File No: NTH06/00905; CR2014/004675
Your Ref: MP06_0258

**Section 75W Modification No 8 - Casuarina Town Centre.
Concept Approval and Project Application Approval 06_0258.**

for Monica Sirol
Network & Safety Manager, Northern Region

GROUND FLOOR PLAN - STAGE. 1

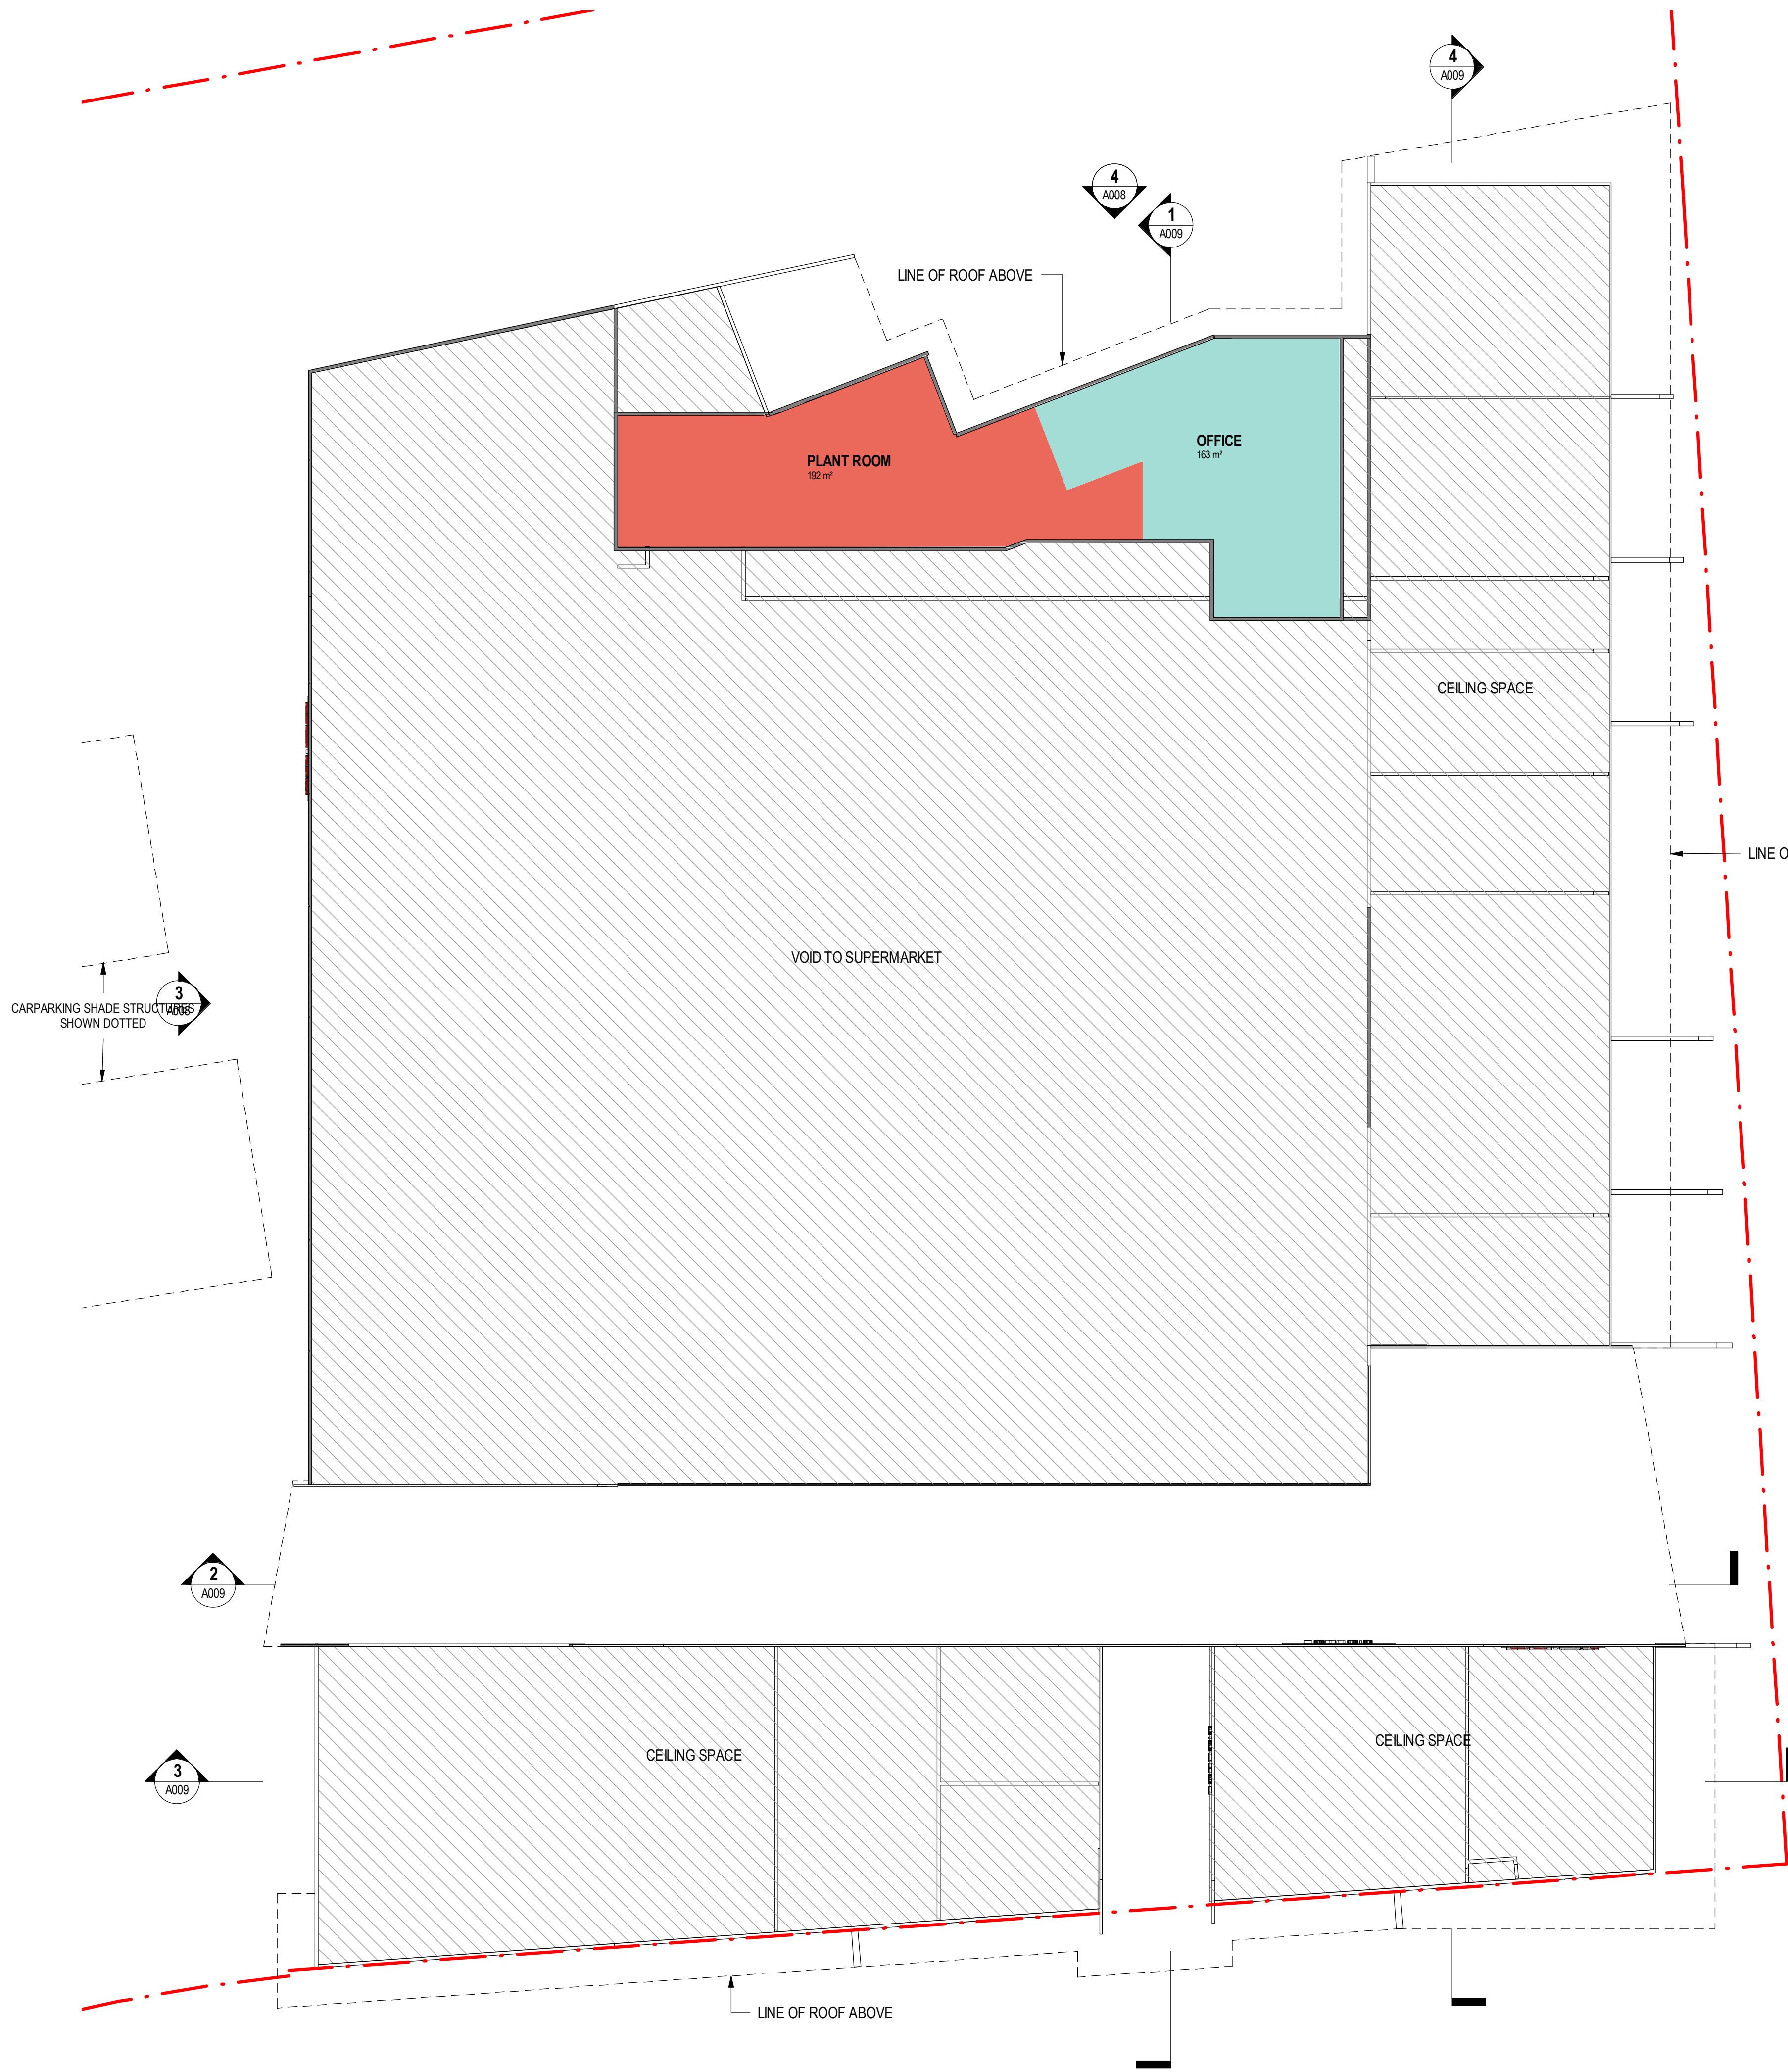
- A Vehicle Management Plan should be required to address all potential conflicts between vehicles and pedestrians within the loading area. Appropriate procedures should be adopted by the site operator to minimise any safety risk.
